Planning Application No: 3/2026/0032

Proposal: Installation of externally illuminated fascia sign, internally illuminated hanging sign and 2 no. illuminated window poster signs

Location: 19 – 21 Berry Lane Longridge PR3 3JA

Elevations - Signage
Proposed

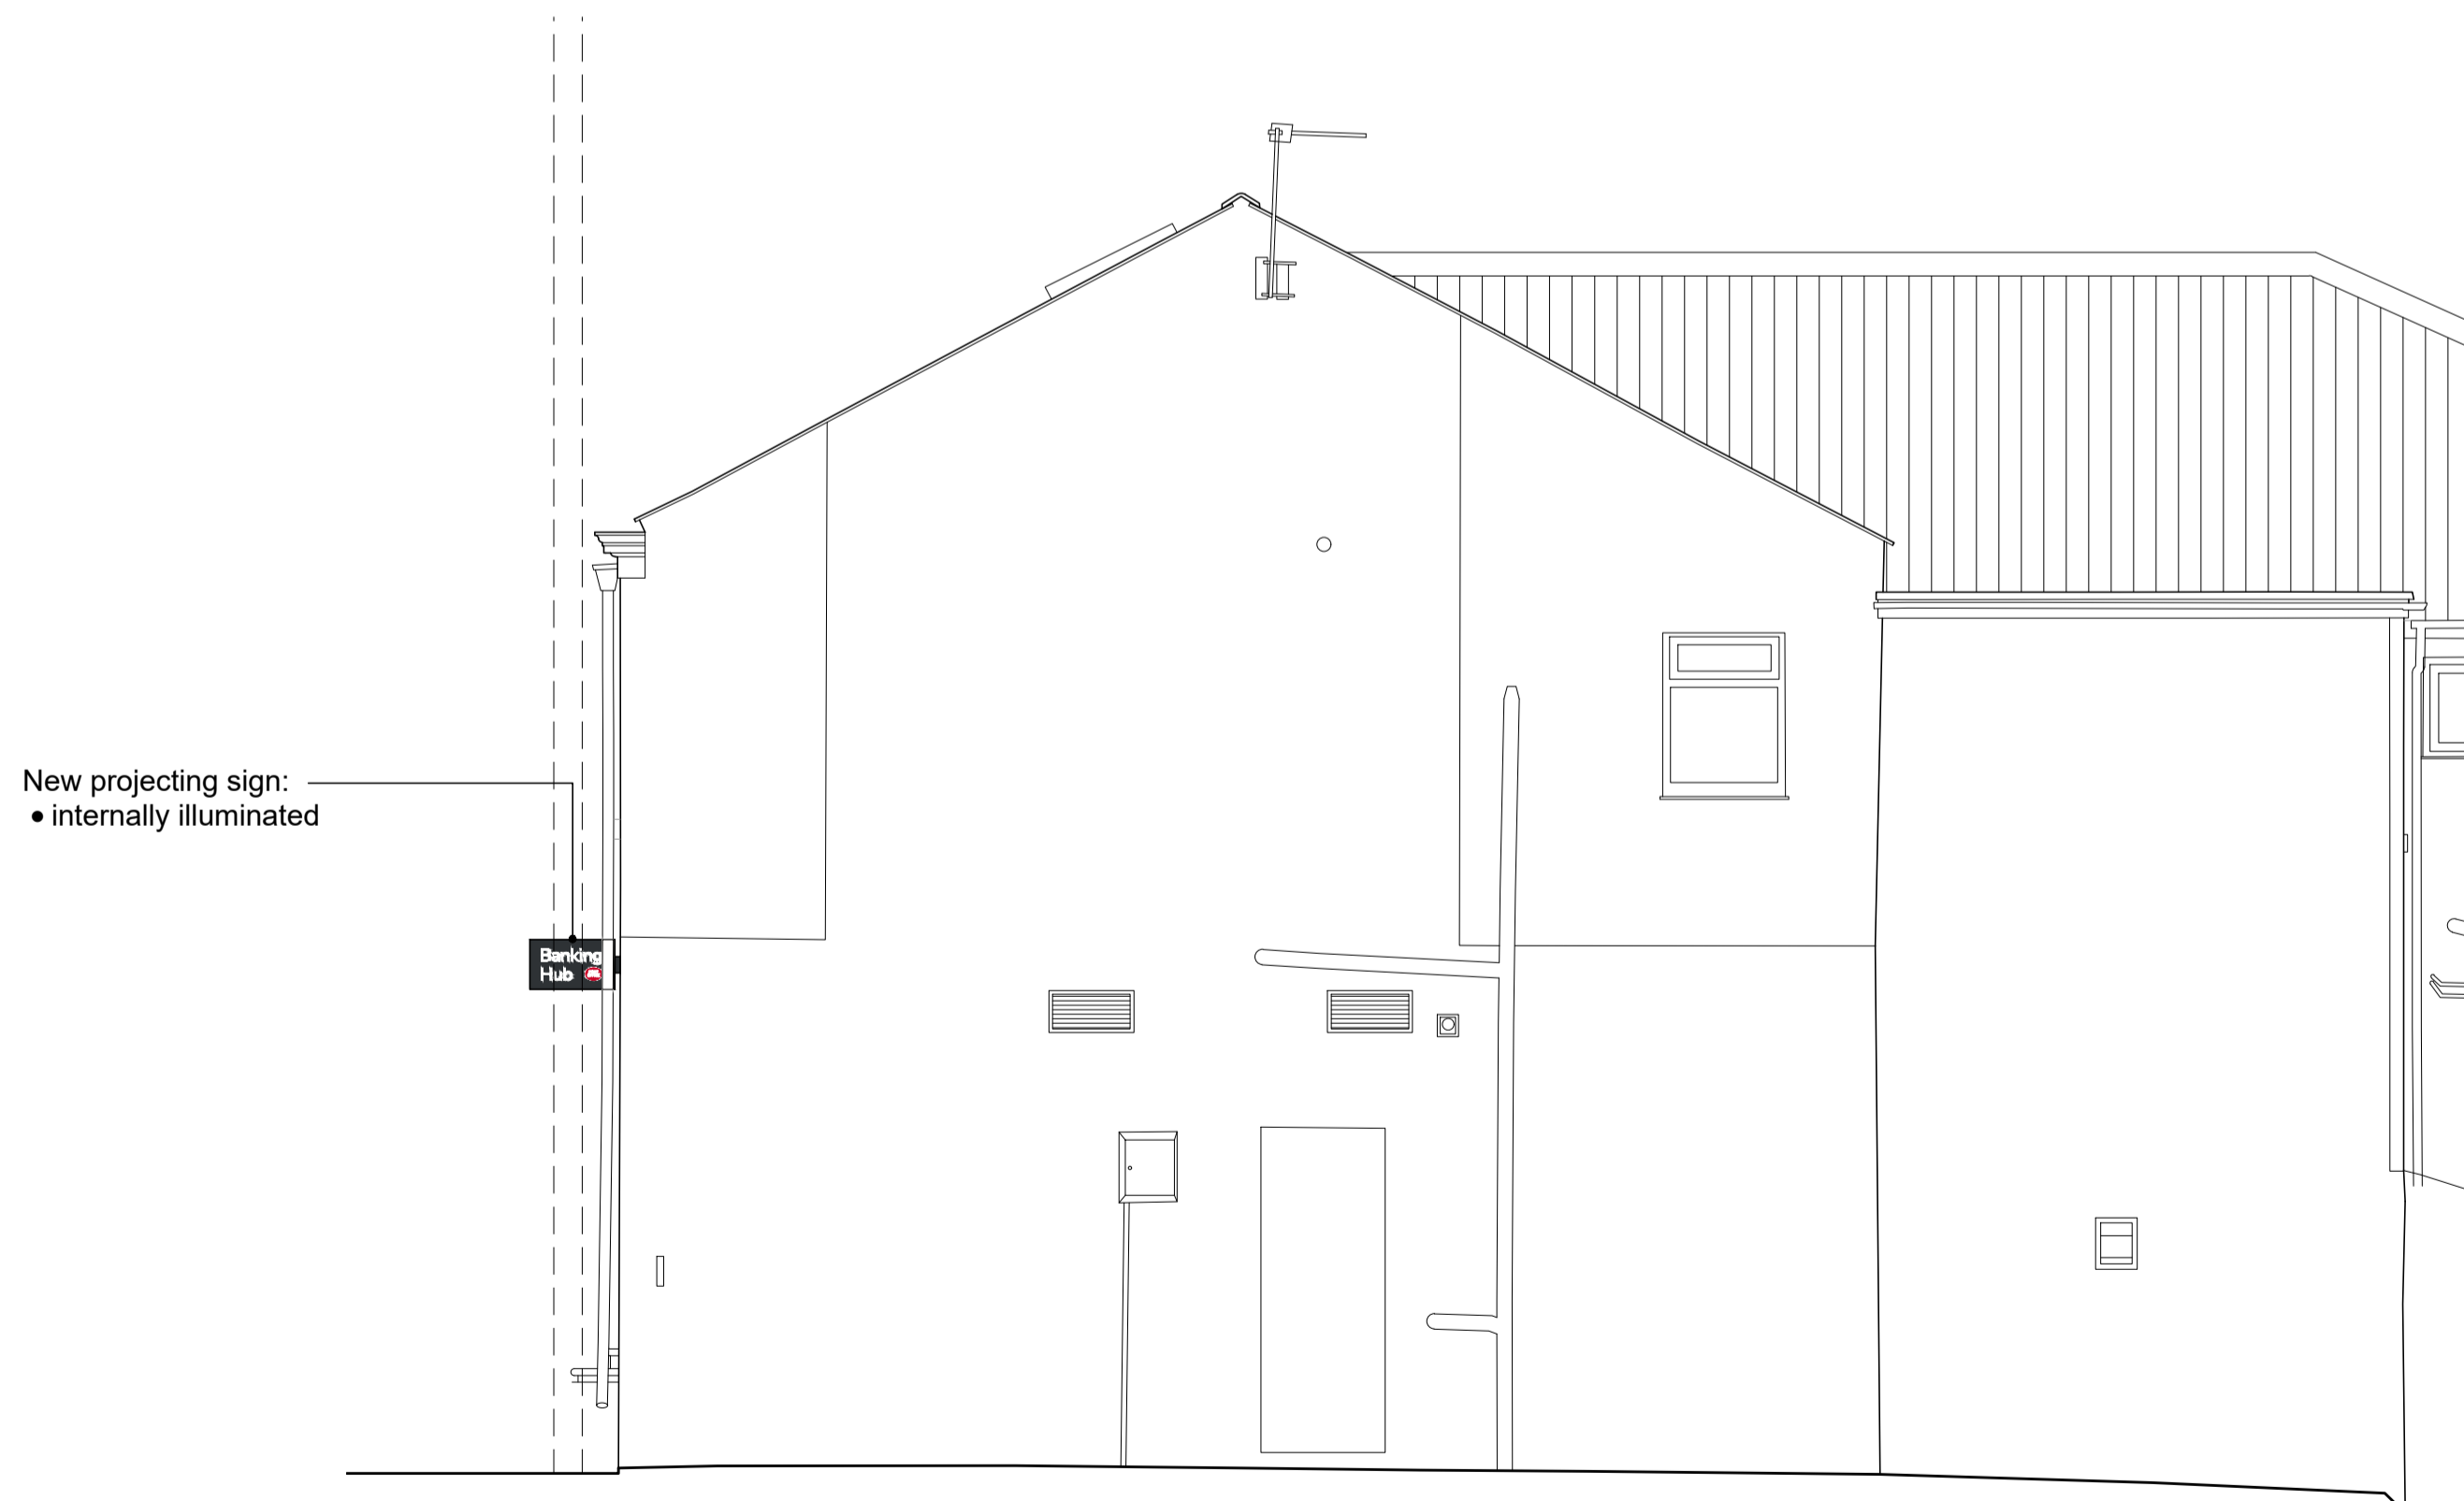
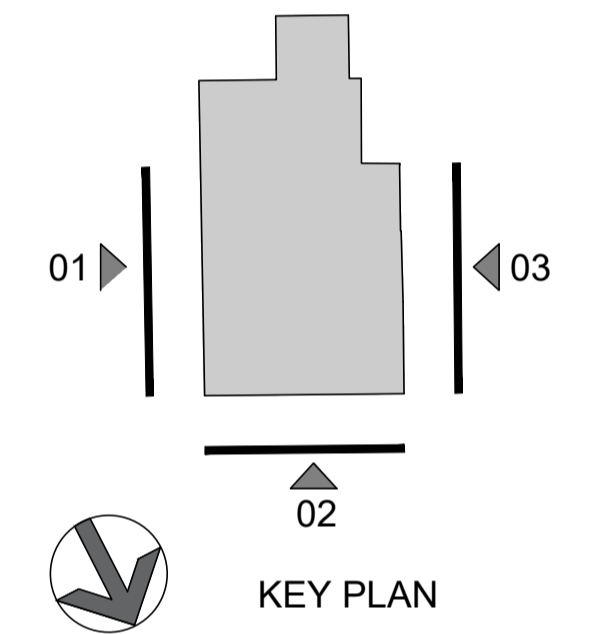
The application has been updated with the following description as requested: Installation of 2 no. new condensers to the side elevation of the property A 1:200 existing and proposed site plan has now been added to the application. The application has been updated to include details of the two illuminated signs in the window. The application has been updated with the following description as requested: Installation of externally illuminated fascia sign, internally illuminated hanging sign and 2 no. illuminated window poster signs. Drawing HUB233-LHA-XX-00-D-A-00003 has been added to the application which details only signage on the elevations.

- The limits of the illuminance shall not exceed 600 candela per square metre. Reason: To avoid glare, dazzle or distraction to passing motorists.

- Any external source of lighting shall be effectively screened from the view of a driver on the adjoining public highway. Reason: To avoid glare, dazzle or distraction to passing motorists.
